CARLTON COTTAGE
HIGH STREET : ANGMERING VILLAGE
WEST SUSSEX : BN16 4AW

9th, January, 2015

Ref : A/165/14 Littleworth House

PROPOSED FLOOR PLAN

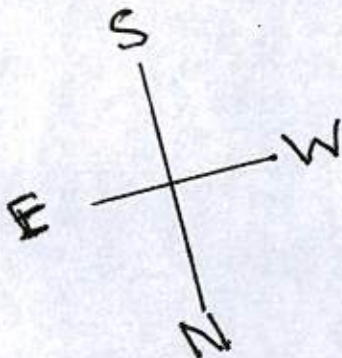
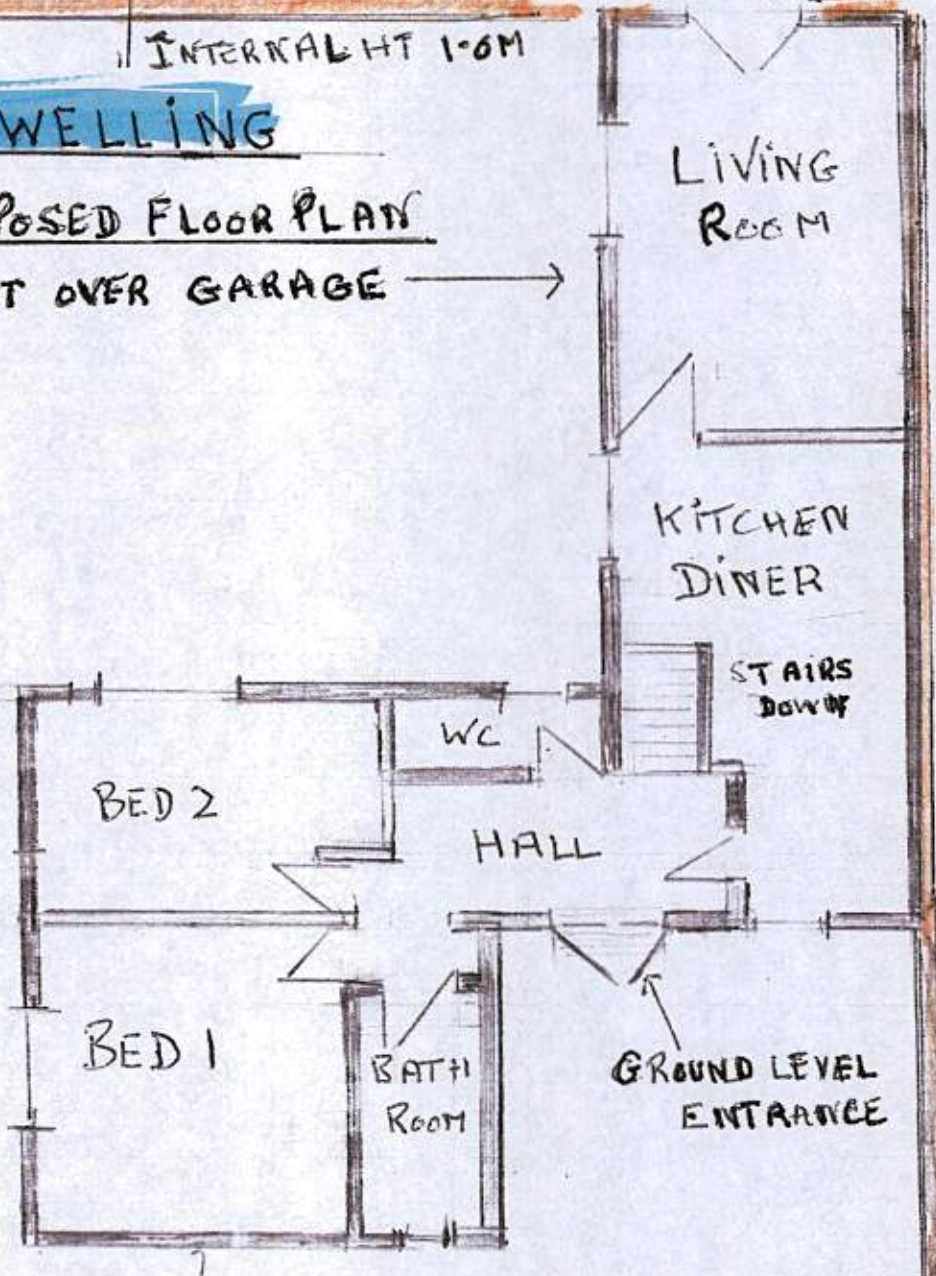
- 5.) Plans L & M differ in that on one the new garages are shown as being parallel to the road whilst on the other they are shown at an angle.
- 6.) The building is described as being single storey. In fact it would be a split level two storey development with the living room on the first floor and the garages on the ground floor. No height measurements are given but, by rough scaling up, it would appear the ridge height at the southern end adjoining the road would be about 6.3 metres high.

- 7.) There does not appear to be an elevation plan for the west elevation.
- 8.) The plans suggest that there will be a wall separating the new building from Littleworth House. This would mean that the only access to the new build, the door to which is at the back, would be through the garage which it is stated will have same style up and over door as at present.

- 9.) There is no explanation as to why such a small building requires four garage spaces. In fact the plans only show three spaces; parking in the front area would make access/ exit from the other spaces impossible.
